Subject: FW: Response To Application Number AB/135/20/OUT at Land at Ford Road Arundel

In response to my previous request for information the following has been provided/discussed with the applicants transport consultant:

Rev
E

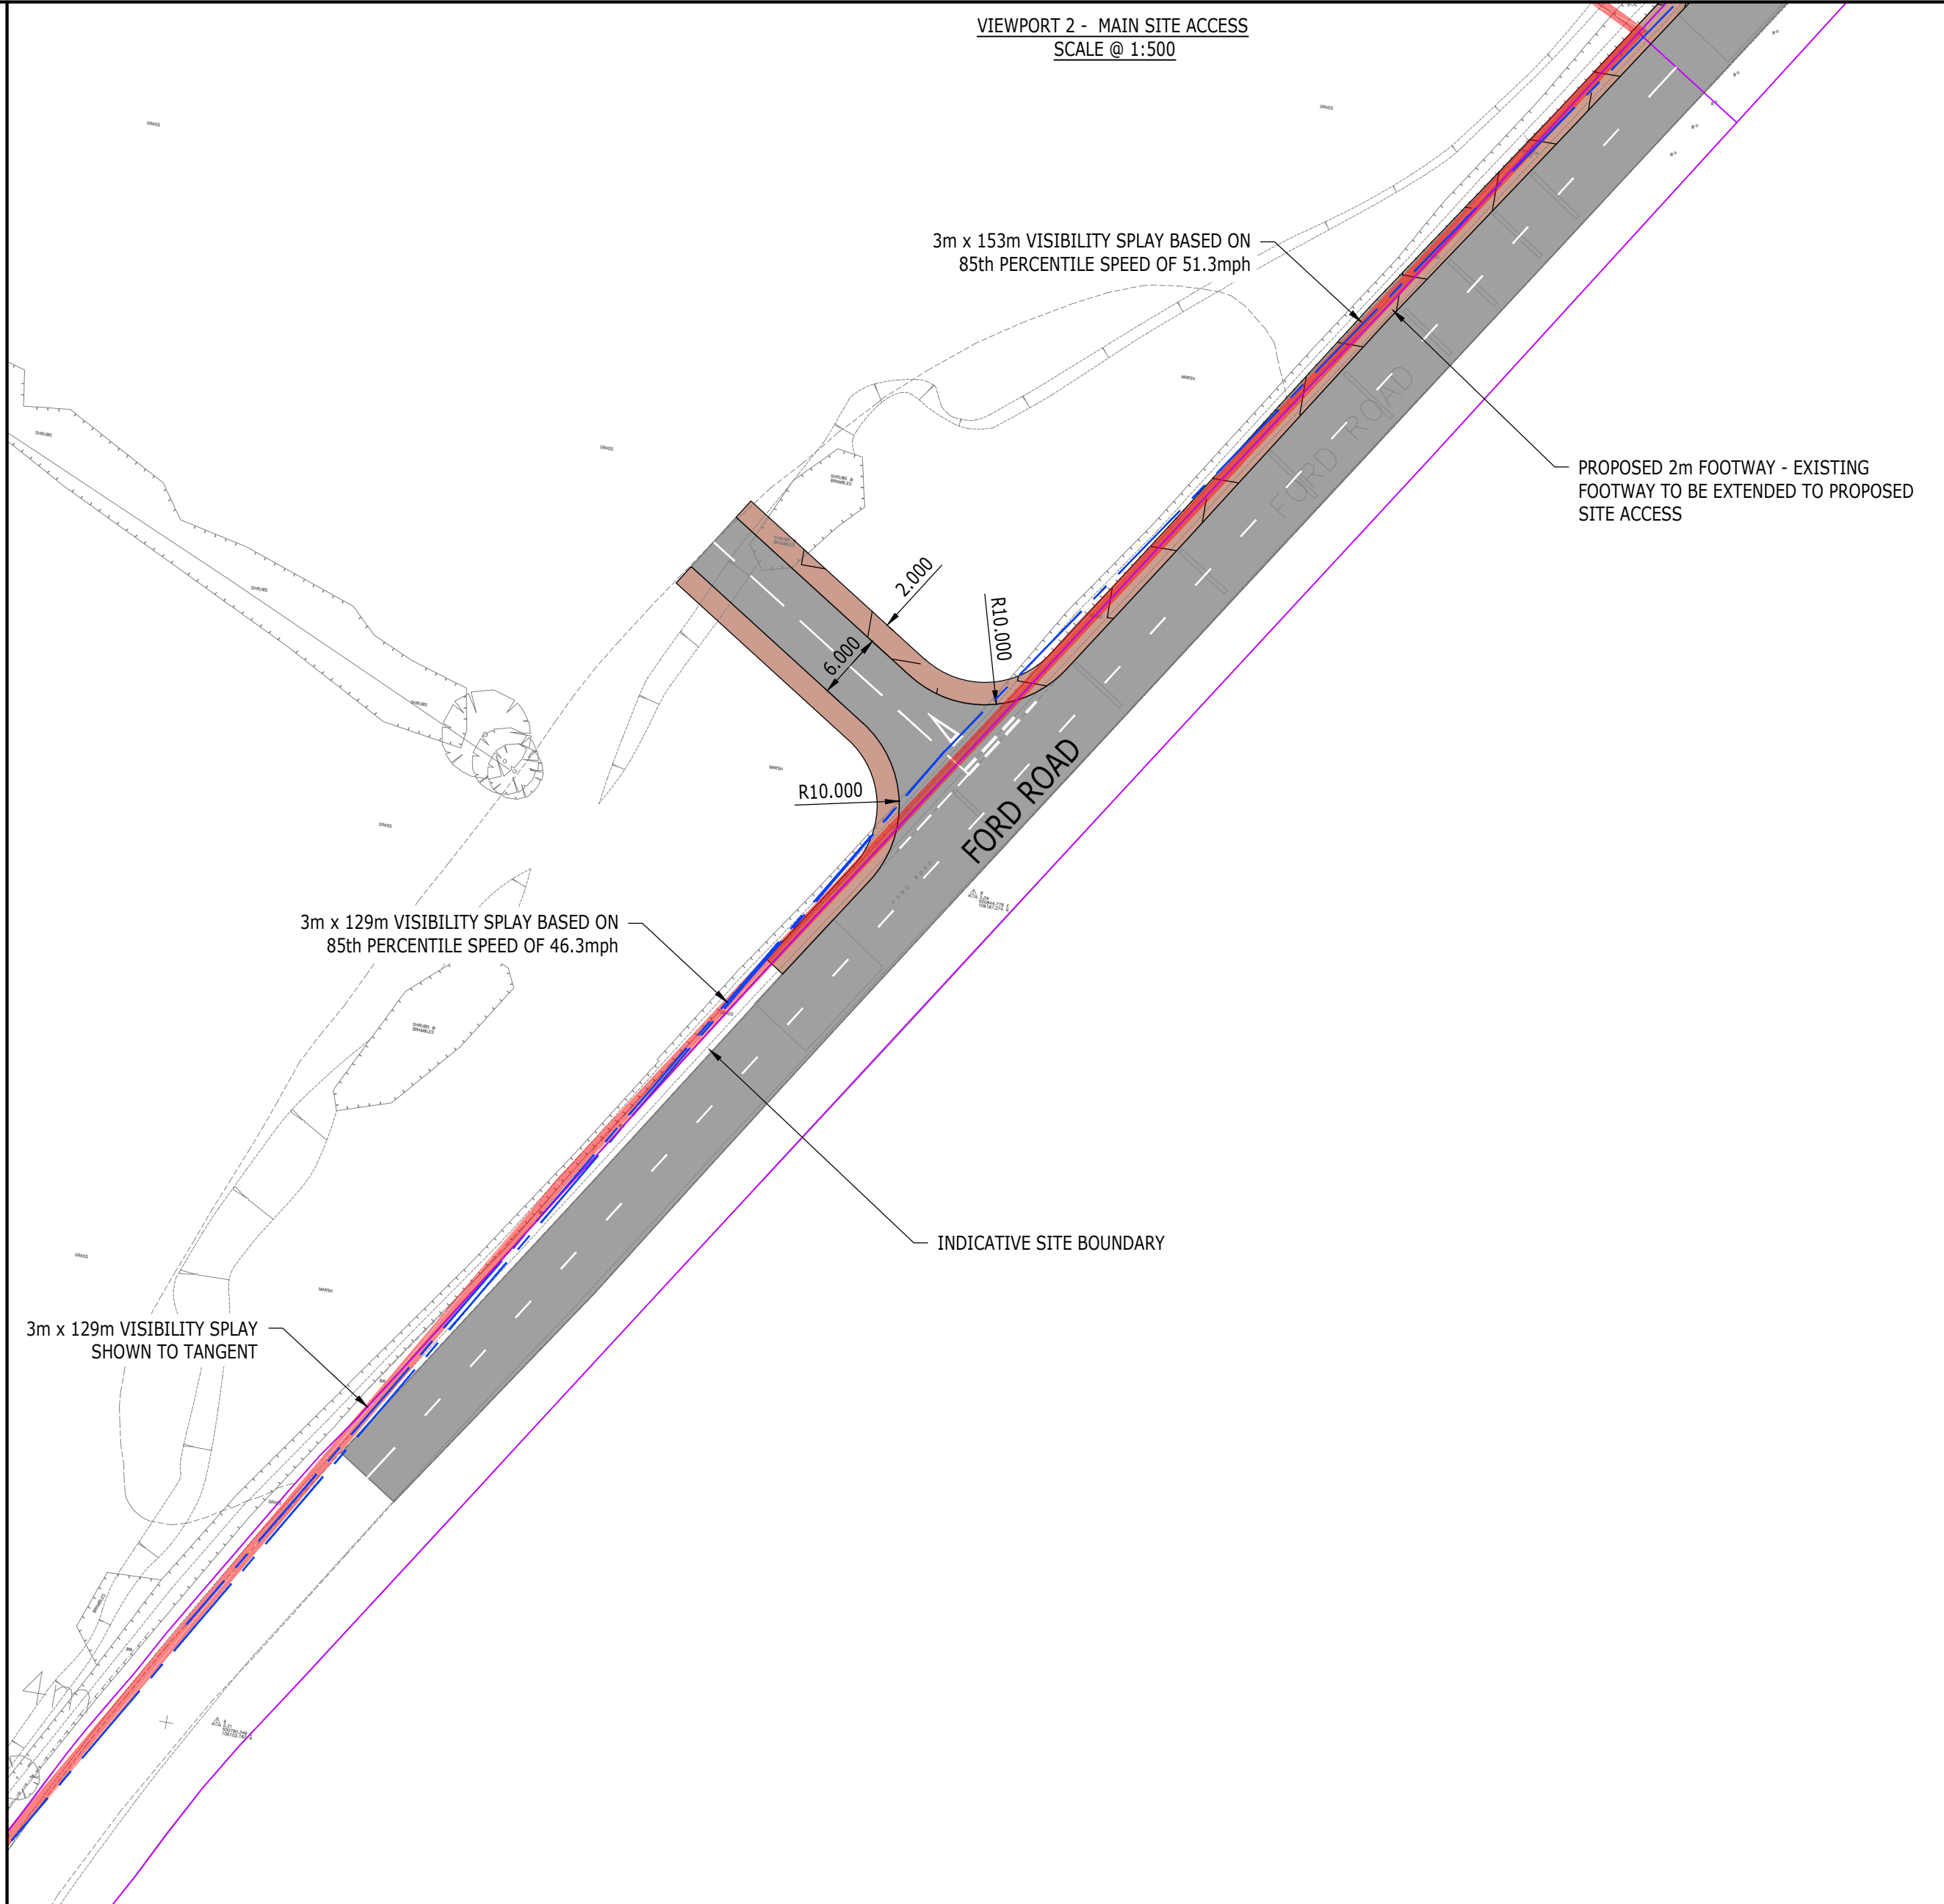
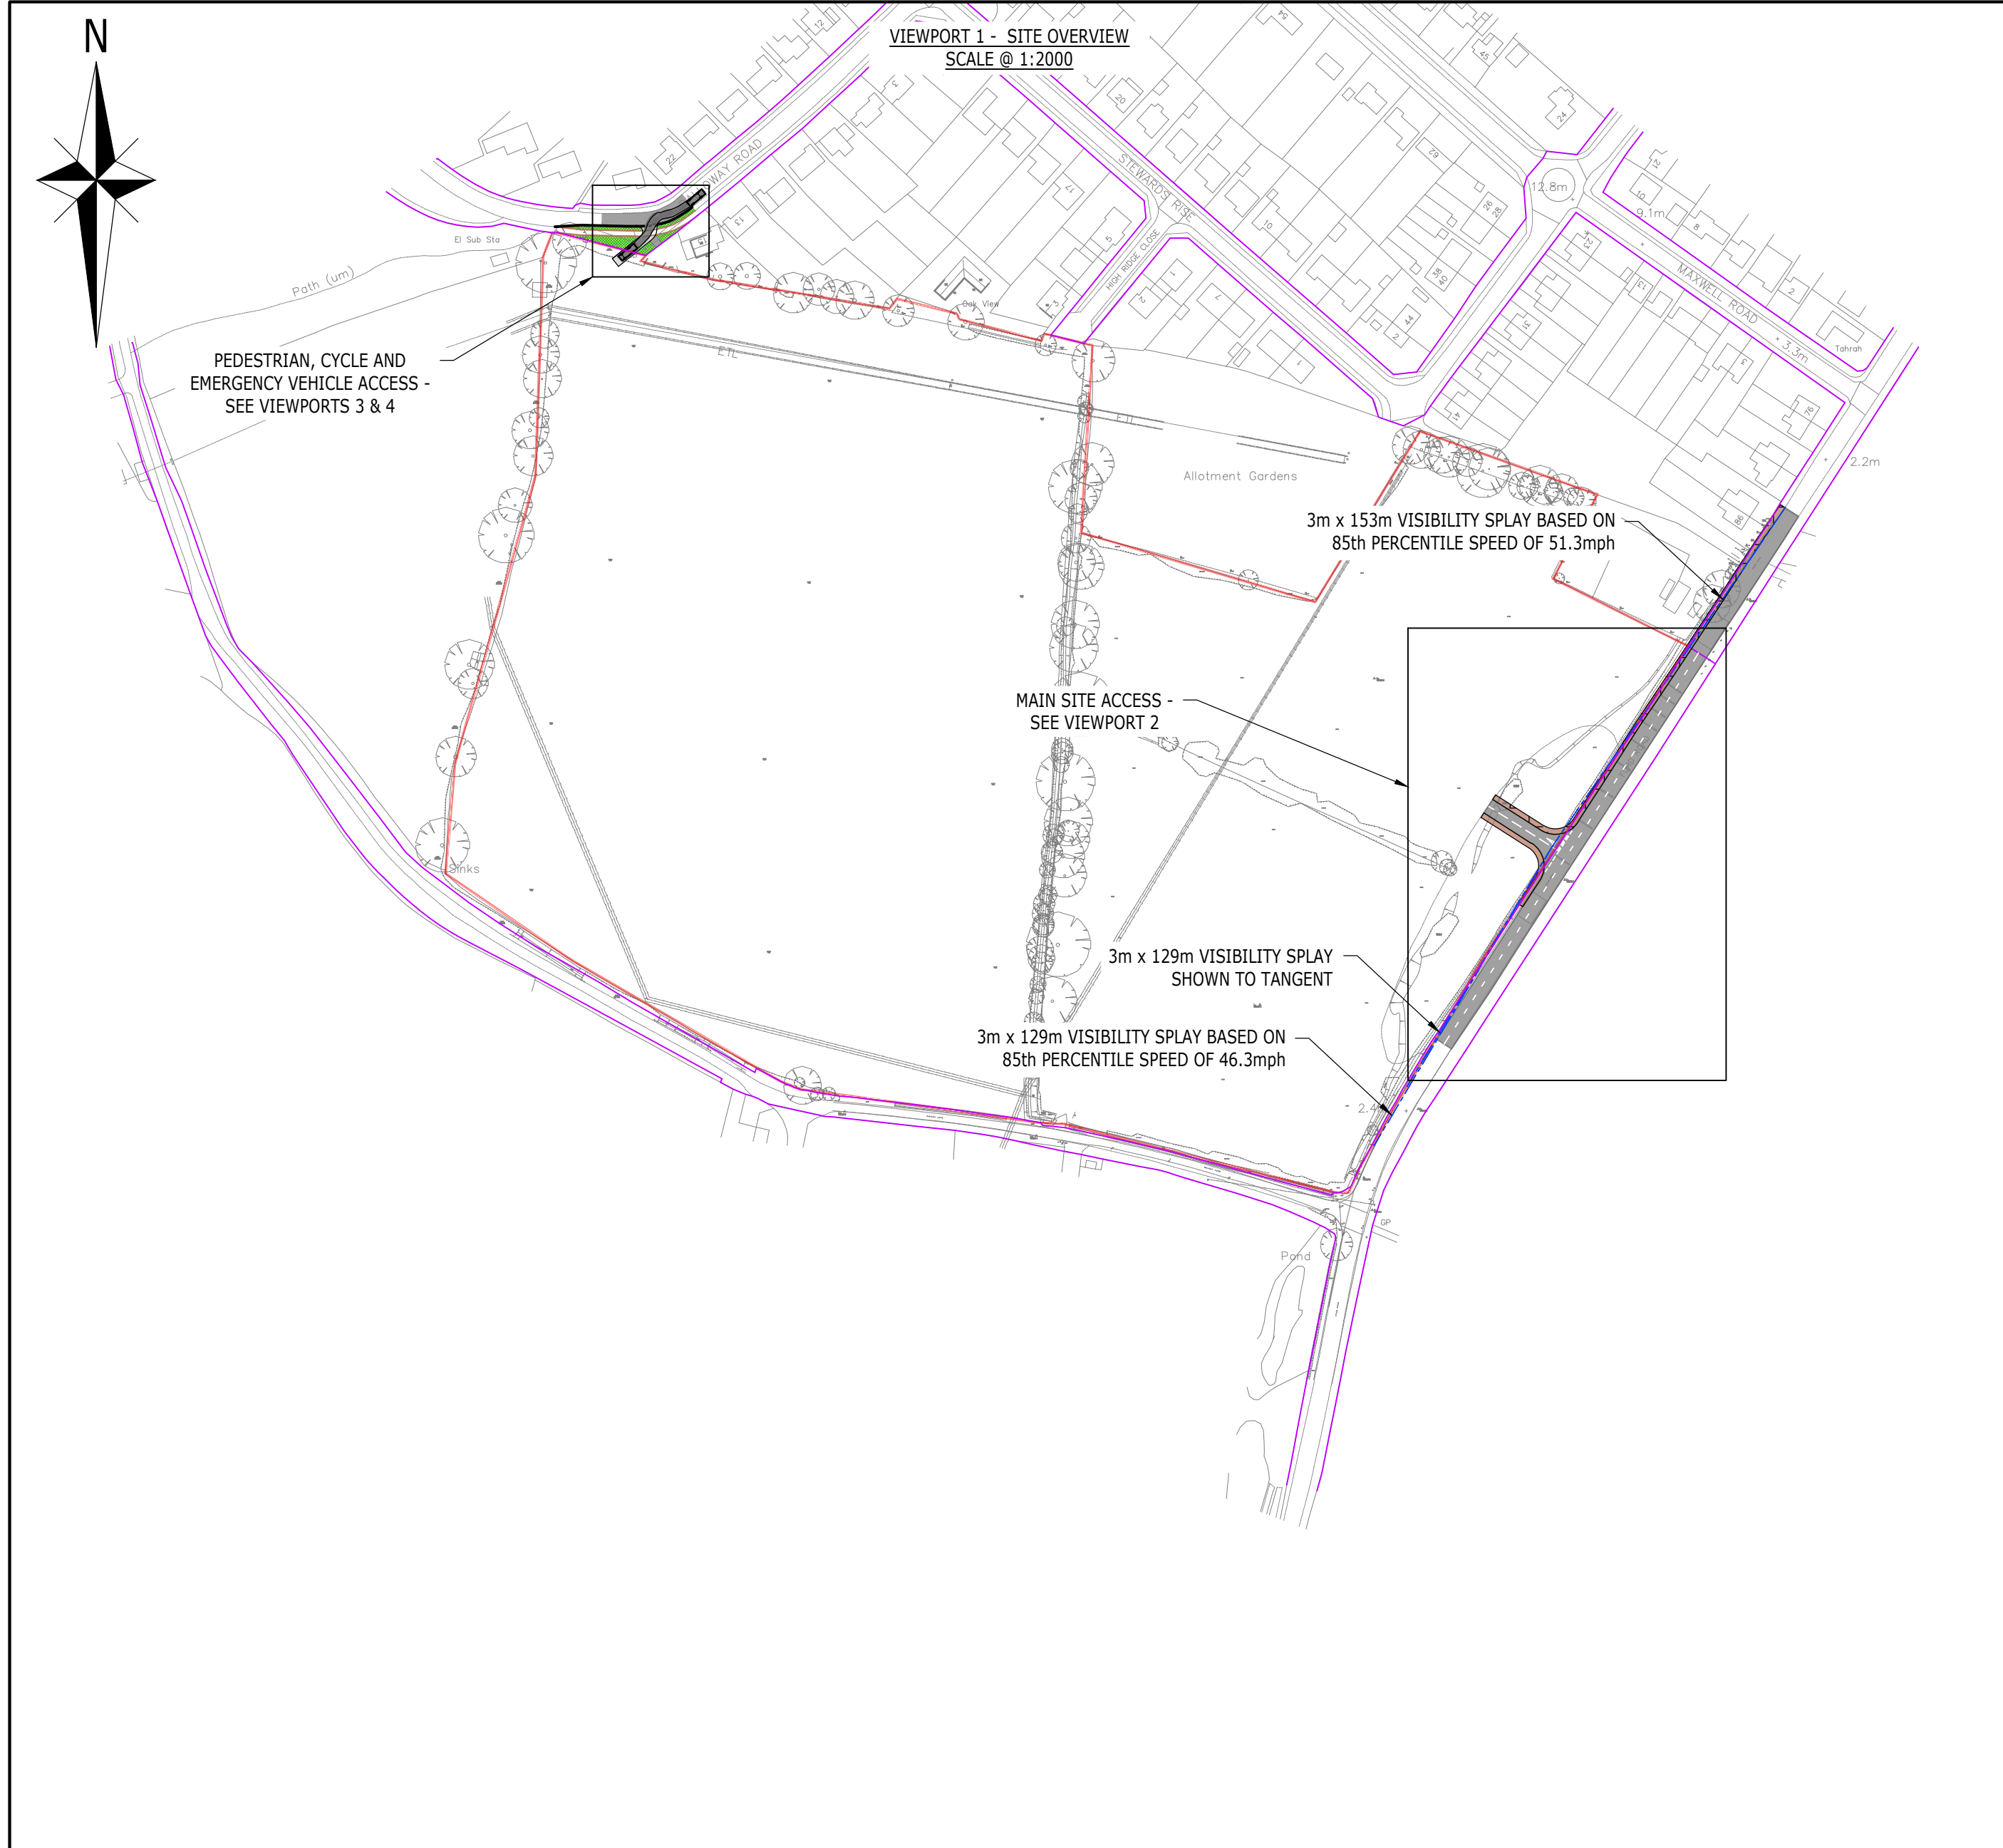
1. Details of pedestrian connectivity/identification of pedestrian infrastructure improvements /pedestrian visibility splays.
- Coloured access plan has been provided which details a footway provision along Ford Road to link with existing provision
- Identification of improvements along the route to local bus stops
- Provision of additional footway and uncontrolled pedestrian crossing with tactile paving for east-west pedestrian movements at the junction of Dalloway Road/Stewards Rise.
- Provision of additional footway and uncontrolled pedestrian crossing with tactile paving for north-south pedestrian movements on Dalloway Road to the west of the junction with Torton Hill Road.

A plan of these has been requested.

- Through discussions it is agreed details of the links to the south will be conditioned (within access timetable condition)

No part of the development shall be first occupied until such time as a timetable covering the construction of the vehicular and non-vehicular accesses serving the development has been submitted to and approved in writing by the Local Planning Authority. The accesses shall thereafter be constructed in accordance with the approved timetable and details shown on the drawing titled site access arrangement and numbered 173483-002 Rev E.
